# Lane Cove Council

19 October 2020

**Lane Cove West Data Centre – 1 Sirius Road, Lane Cove West – MOD 2 Building Modifications and Additional Office Space at 2 Apollo Place. Notice of Exhibition (SSD 9741).**

Project Status	SSD	
Drawing Title	MASTER PLAN - EGRESS DIAGRAM	
Drawing Number	ATSYD2_SSD_DRG_ARC_0900

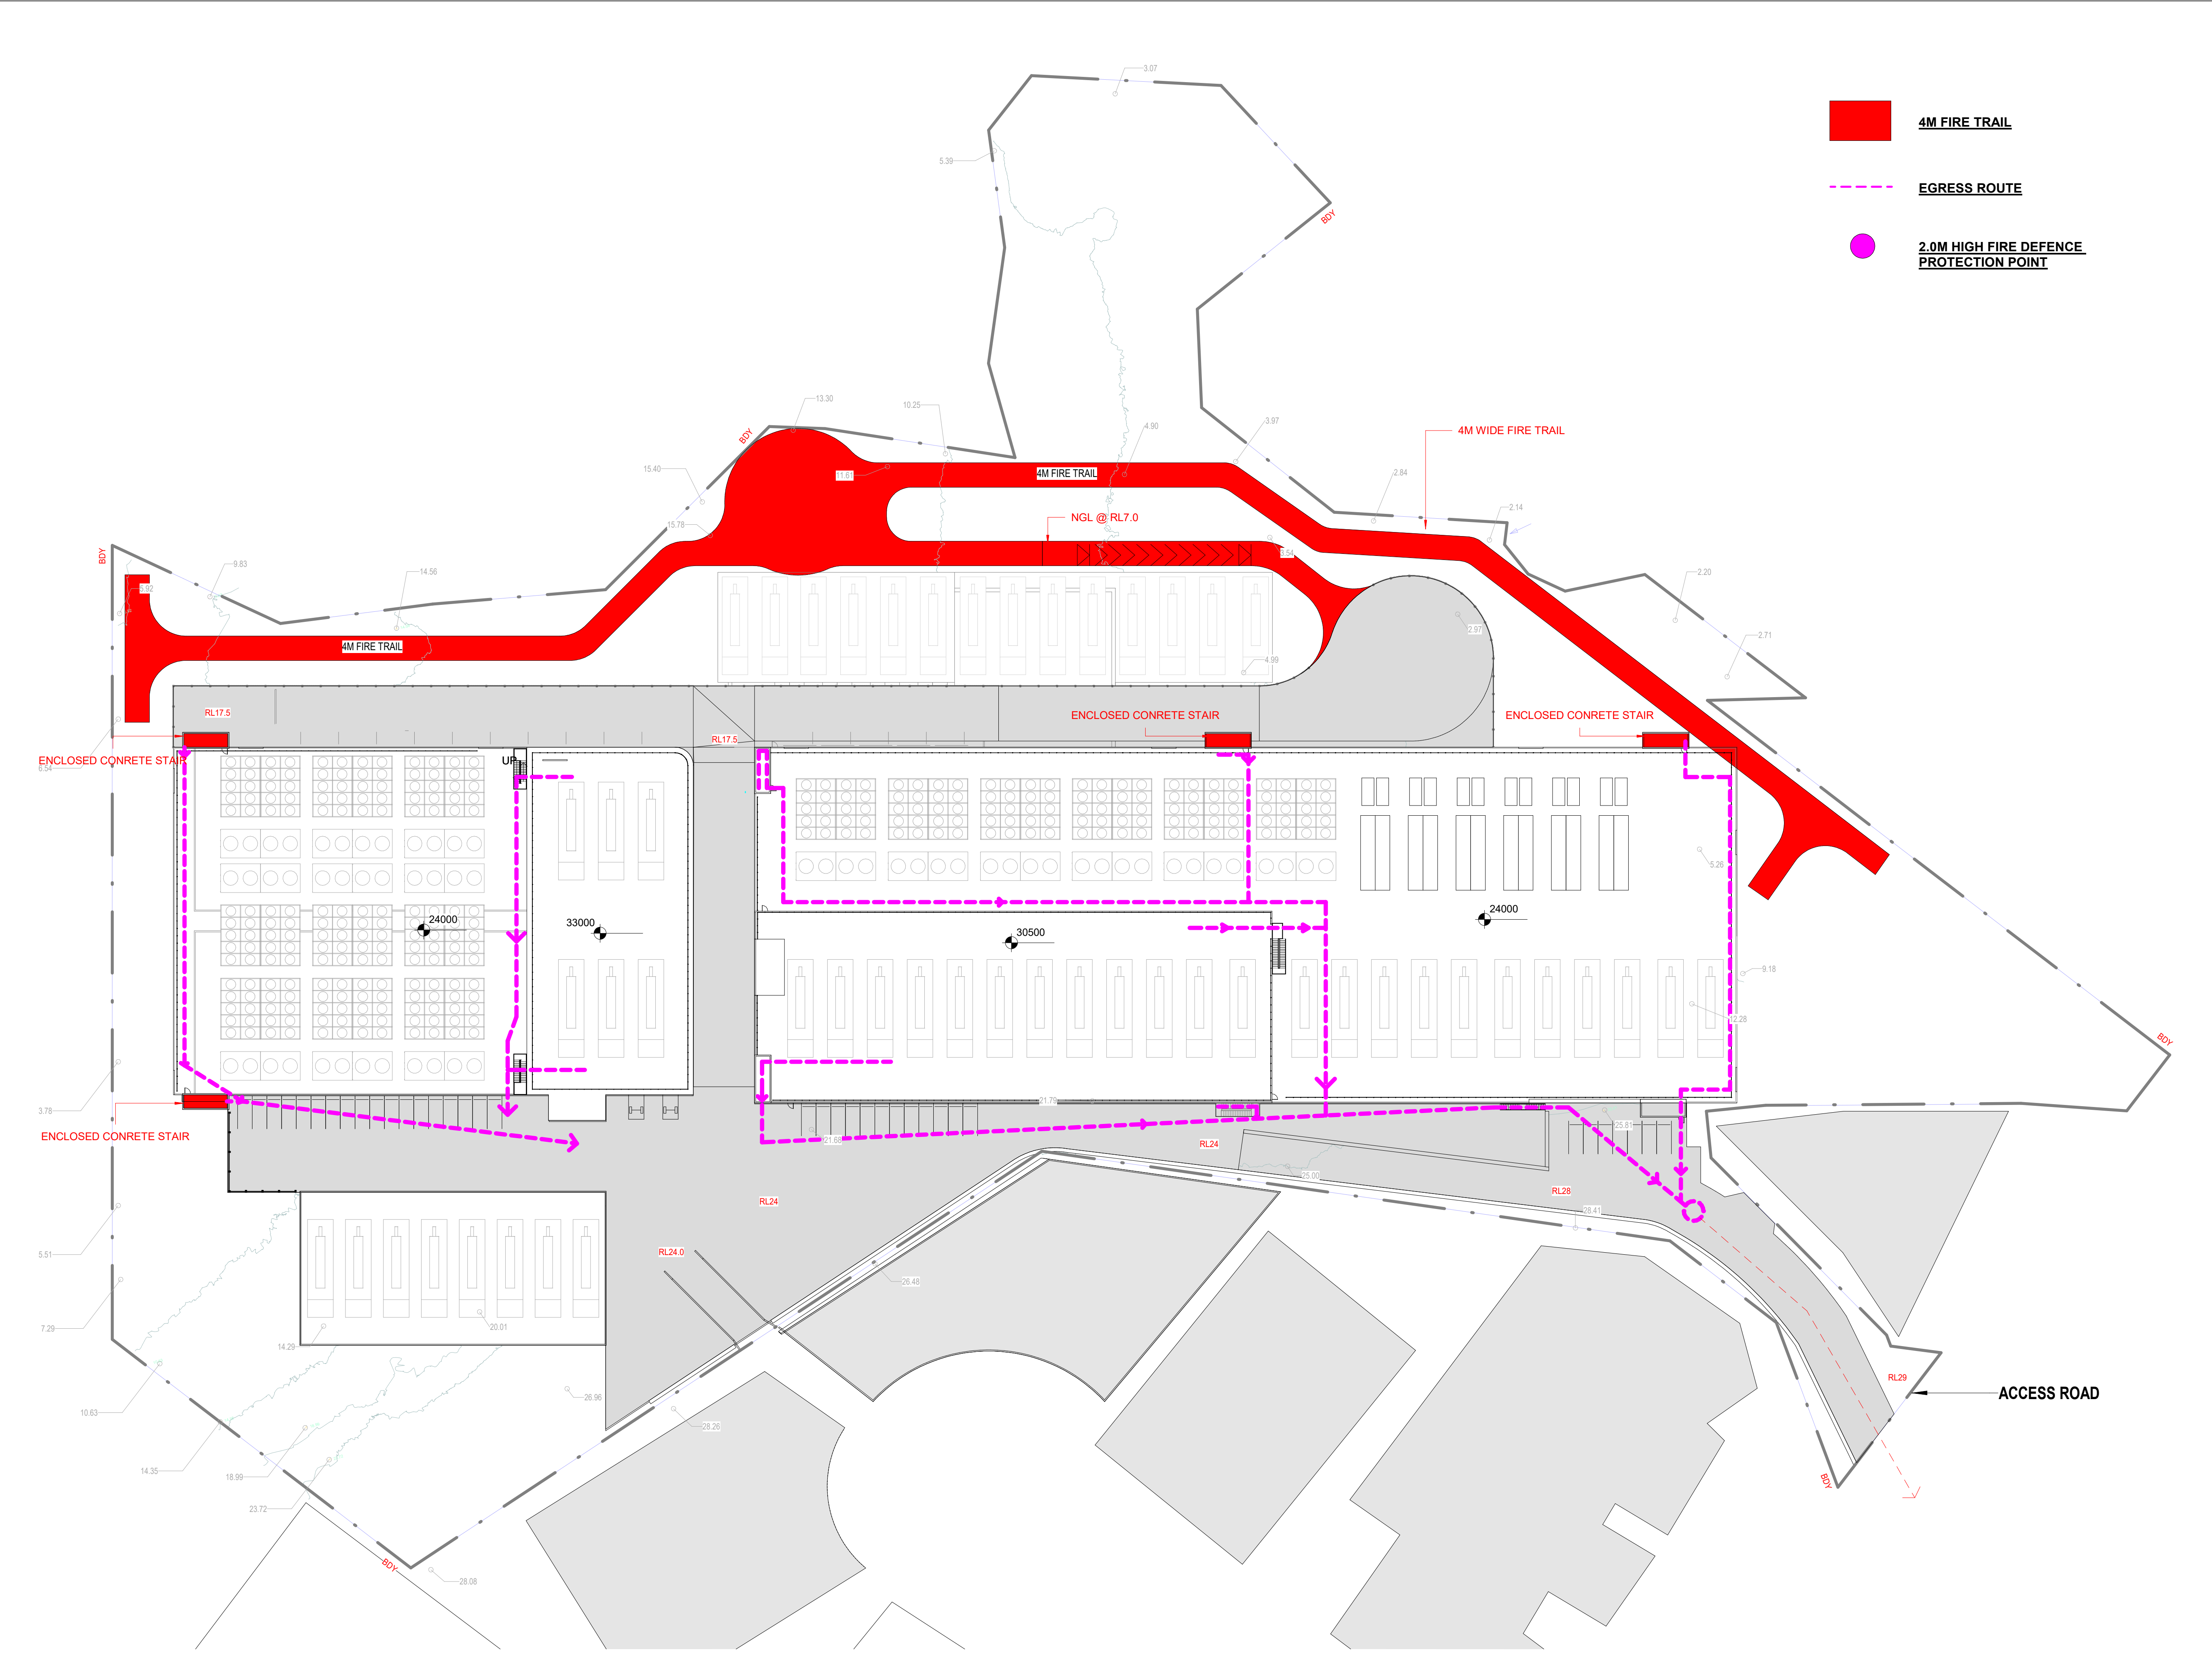
- Please advise if any trees would be removed as part of the proposed extension of the fire trail. Or would this only result in reconfiguration to the proposed bush regeneration area.
- Request for swept path analysis of fire trail (to ensure the clearances are not any wider than they need to be as it is encroaching towards the bushland).
